KIRKLEES METROPOLITAN COUNCIL INVESTMENT & REGENERATION SERVICE

Reference No:	2025/70/92933/E
Site Address:	Land off, Marsh Lane, Shepley, Huddersfield, HD8 8AS
Description:	Variation of condition 2 (plans) on previous permission 2024/91202 for erection of eight dwellings with associated access and external works
Recommending Officer:	Elenya Jackson

DECISION – VARIATION OF CONDITION APPROVED

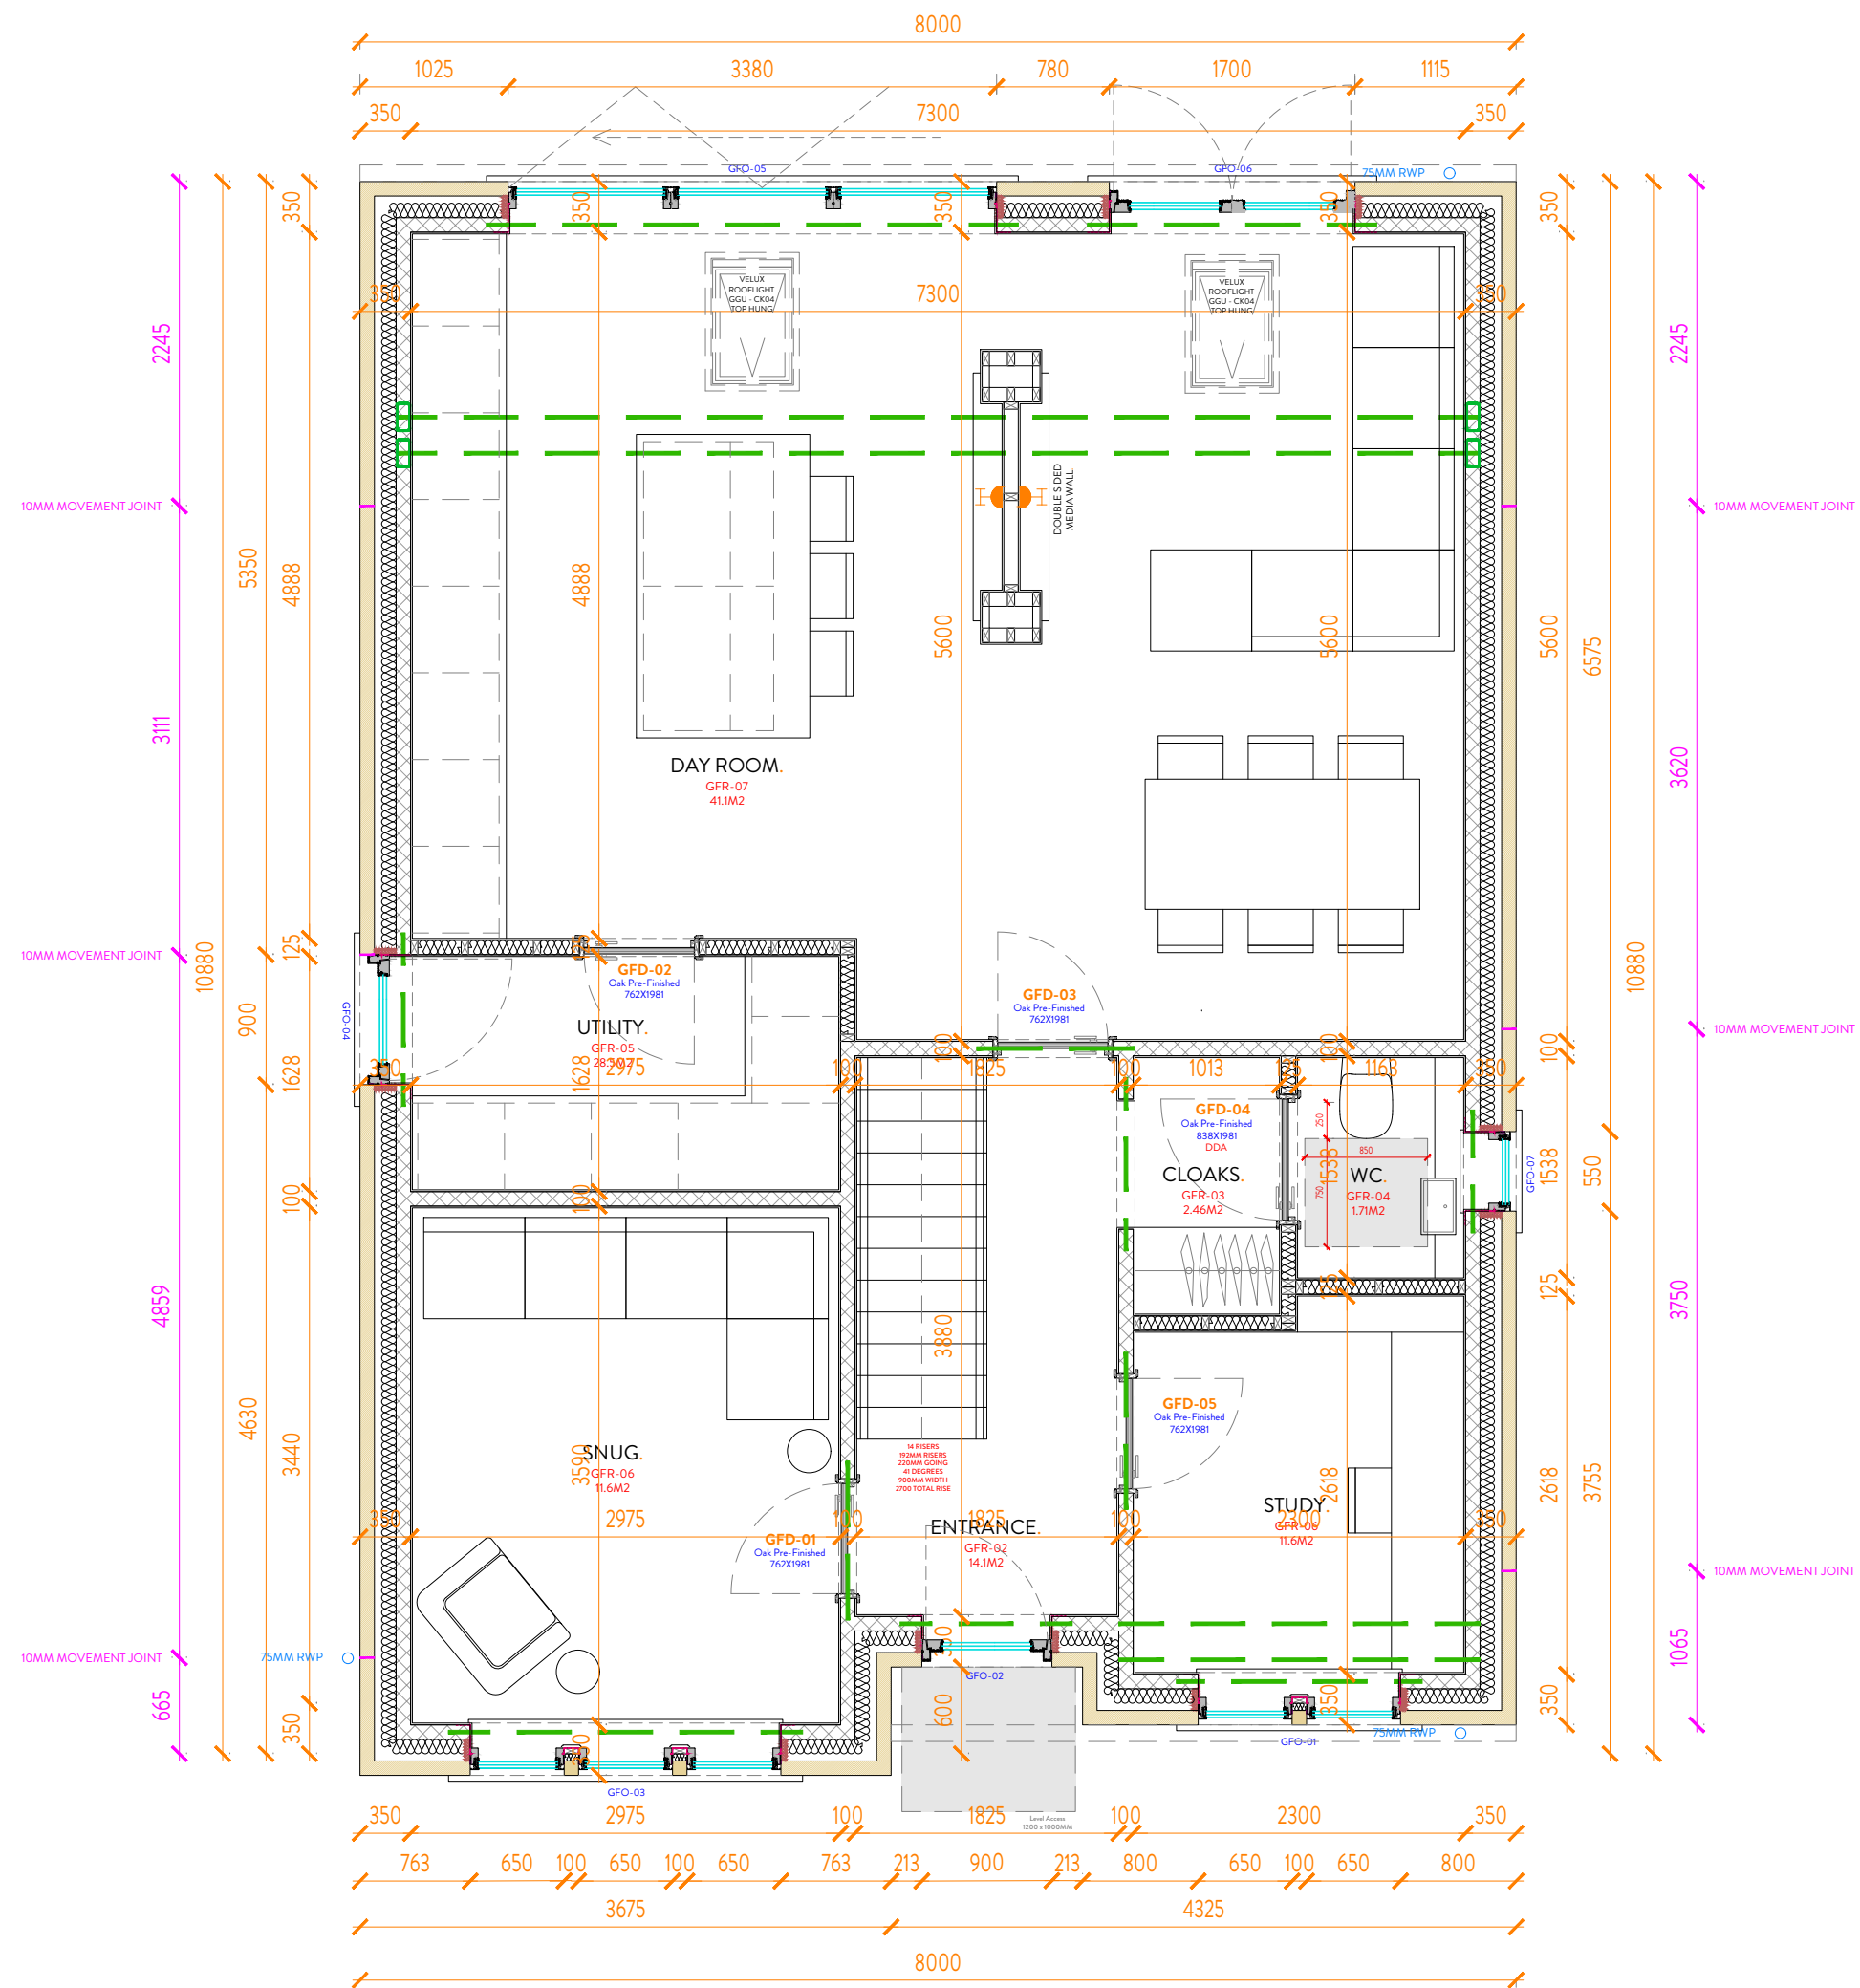
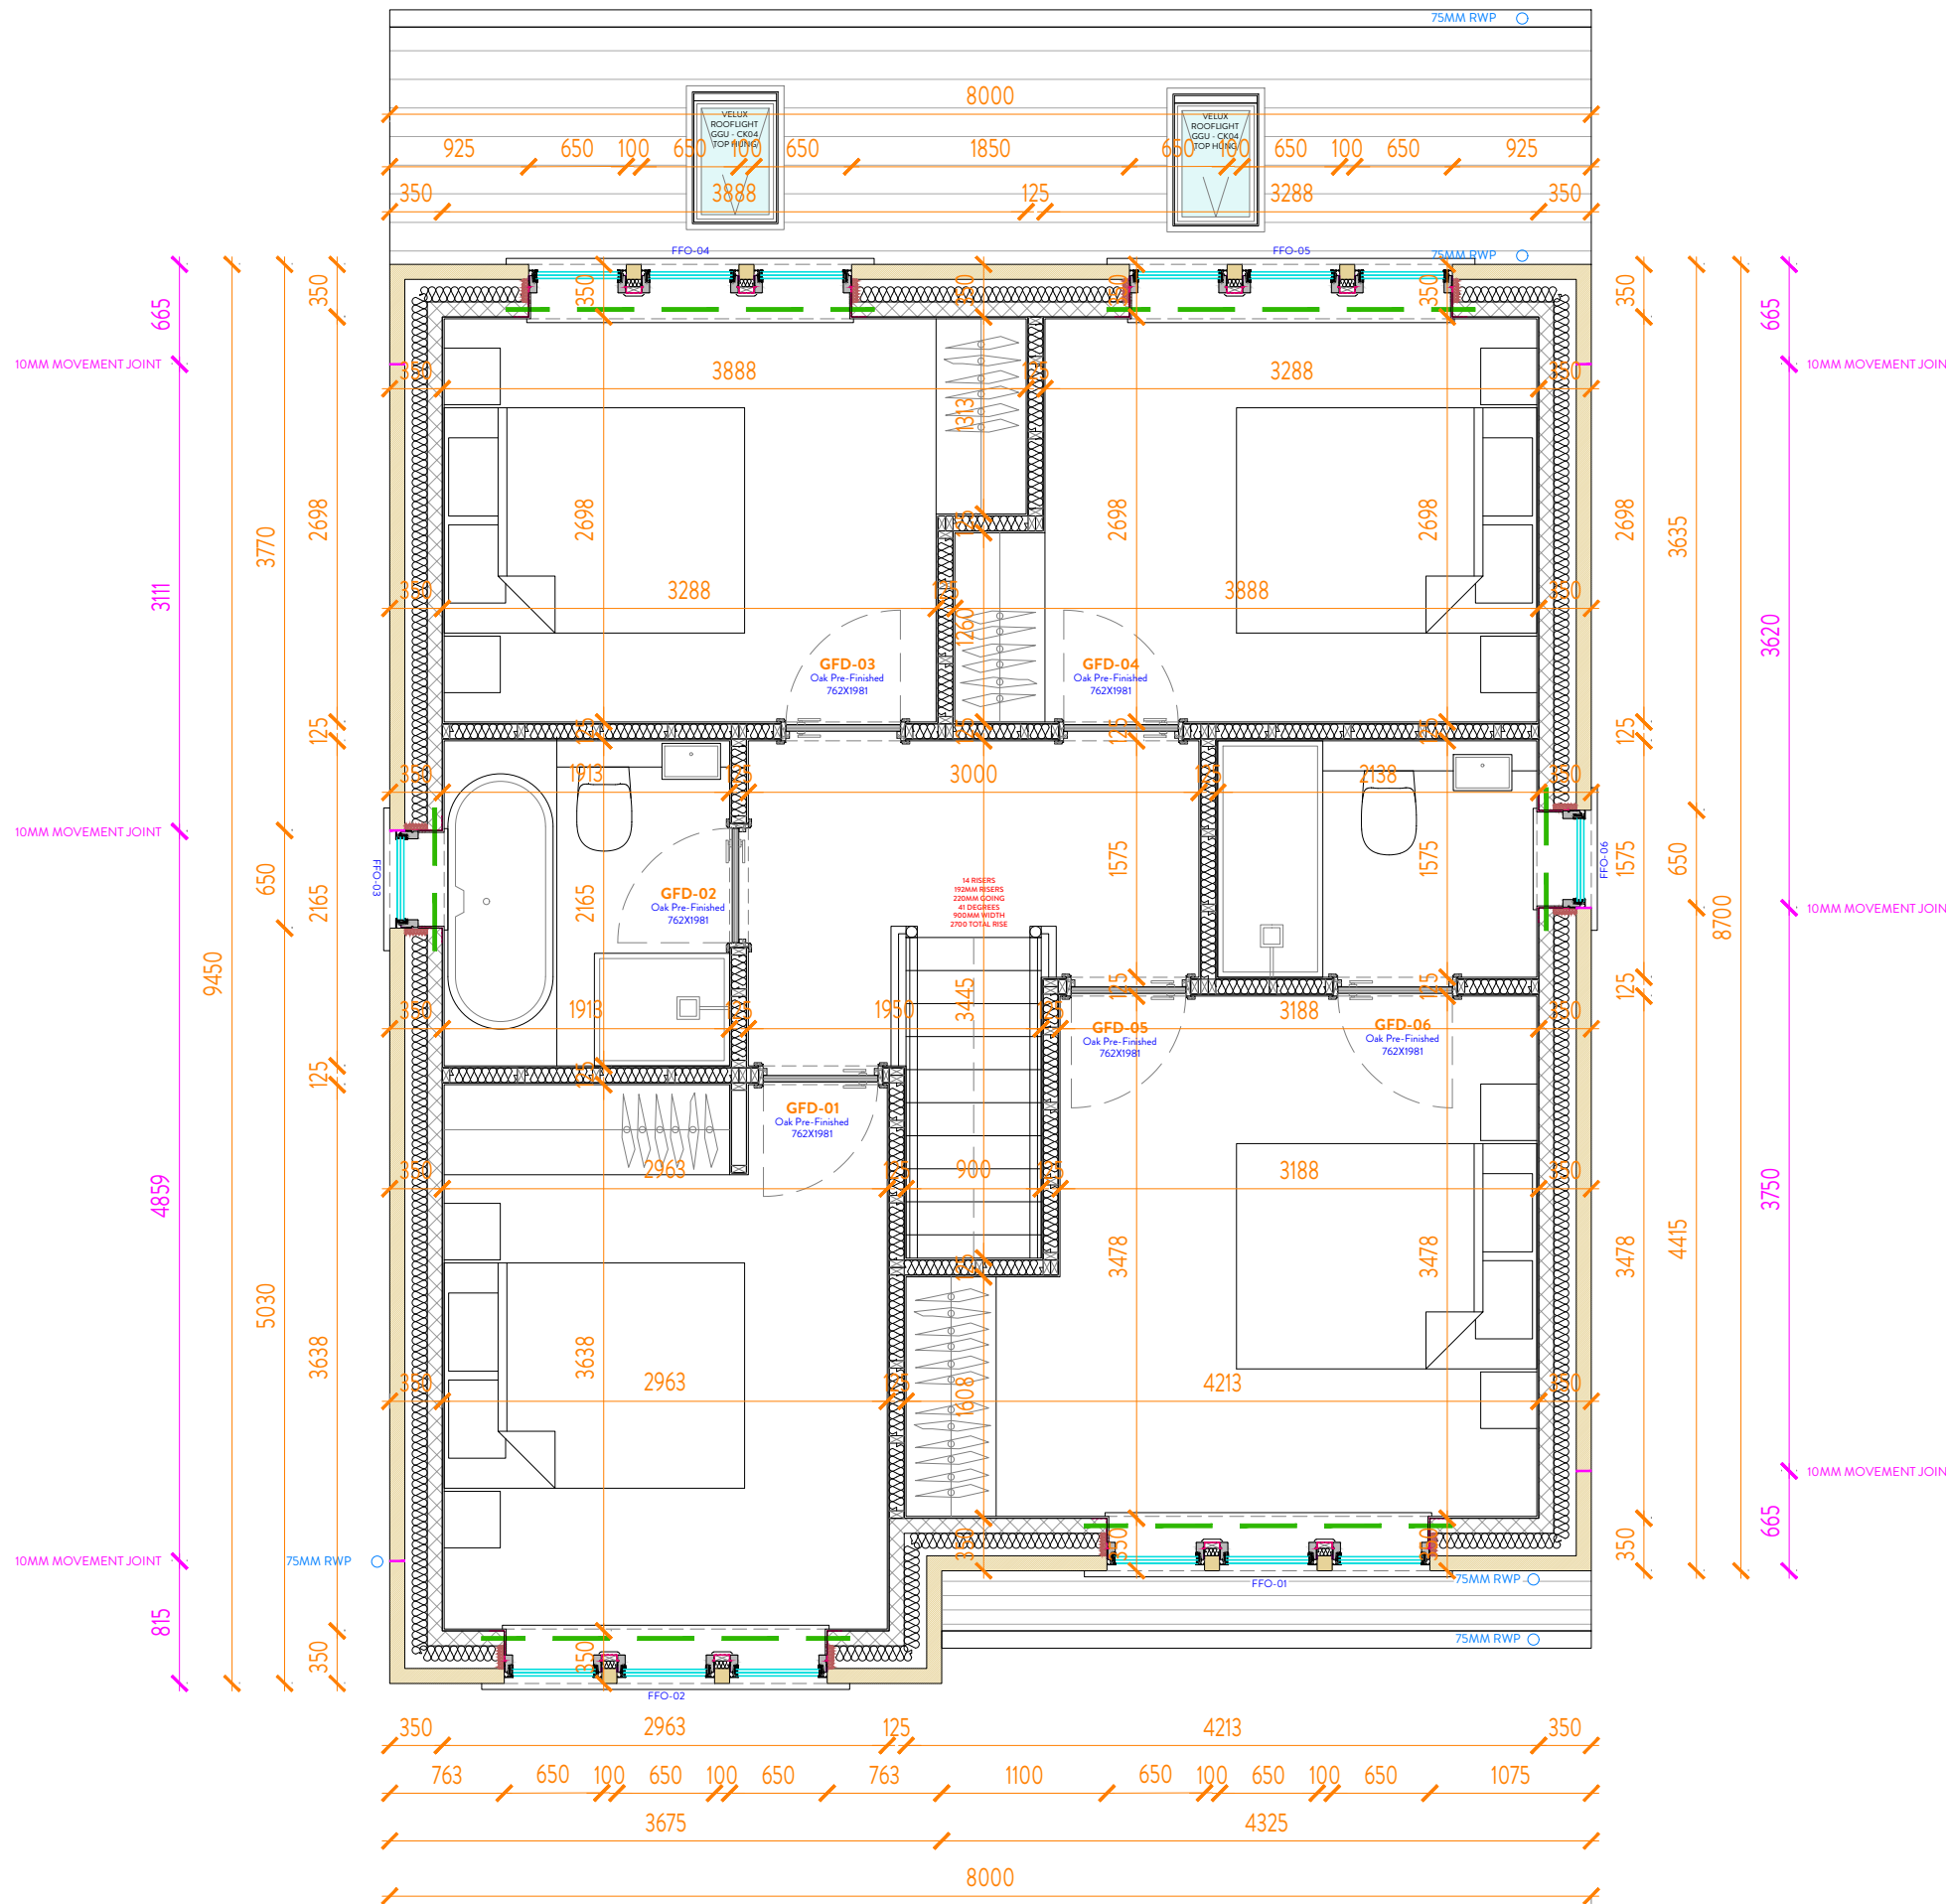
Plot 1

- Addition of a canopy to front elevation
- Addition of window on southern elevation to serve bathroom
- Removal of window at ground floor level on eastern elevation
- Changing internal configuration
- Altering ground floor side door to northern elevation
- Alteration to solar panel layout
